From: Dafydd Lloyd
Sent: 25 September 2014 12:24
To: Peter Cleveland
Subject: RE: Hollyacre Toddington - Ref: LU/234/14/DOC

Please find attached the proposed tree protection plan which seeks to discharge Condition 8 of the planning approval LU/116/13 which is a scheme for 63 dwellings in Littlehampton.

As discussed drawing L(90)1000 attached to indicate more clearly the tree protection.

Drawing Title  
Tree protection - Phase 1

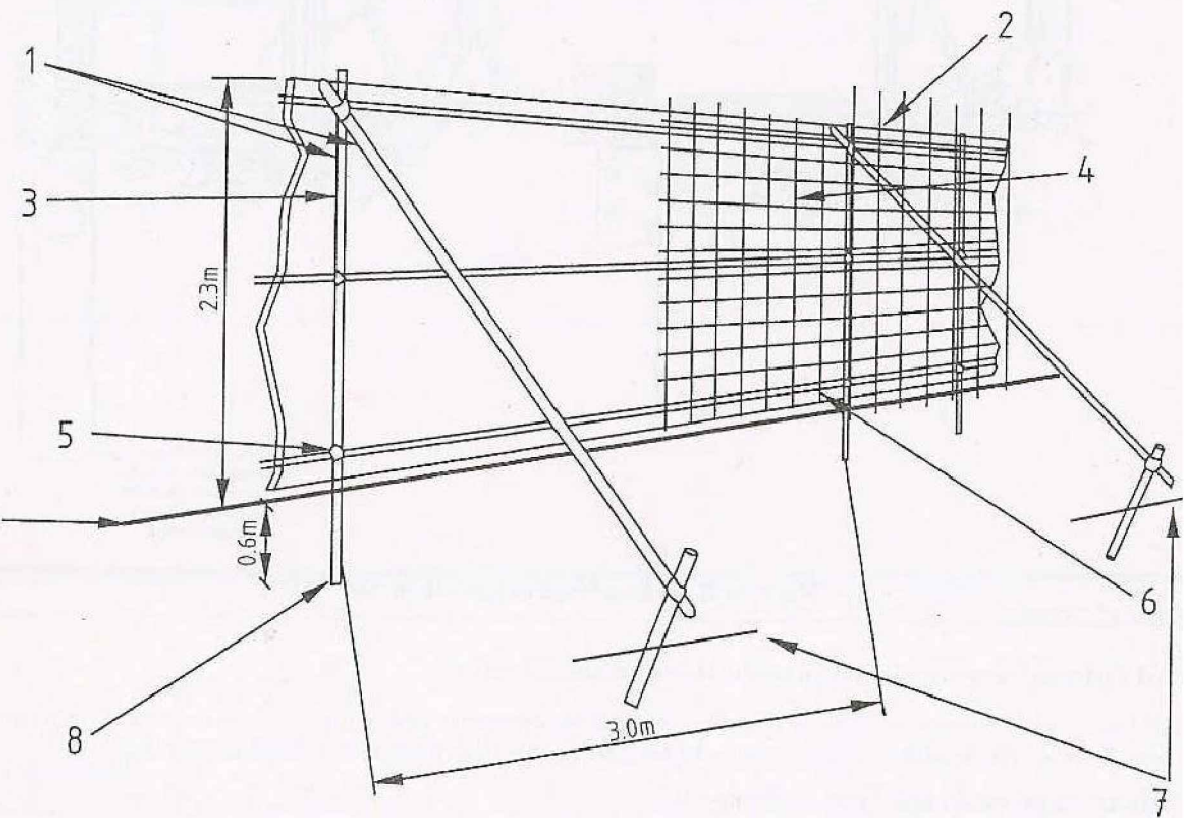
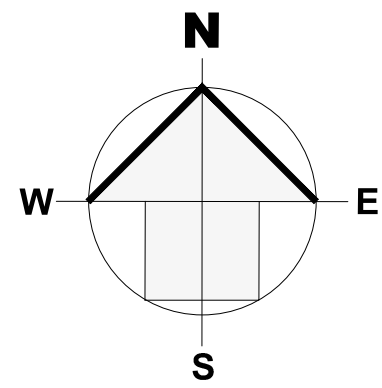
Just gone through this, and all this is the method of BS5837 without any content. All the applicant has done is provided the methods of a surveying, categorising, retention, and then mitigation of these trees without the application of any tree data from the site. The applicant needs to actual produce the data from the surveying. Once the surveying is done a retention and mitigation plan can be produced. The applicant has failed to do this. For these reasons I cannot even comment on this application, as there is no data to comment on. **This is therefore a refusal from me.**

Yeah this is acceptable now! Would you like me to generate a report on this one too?
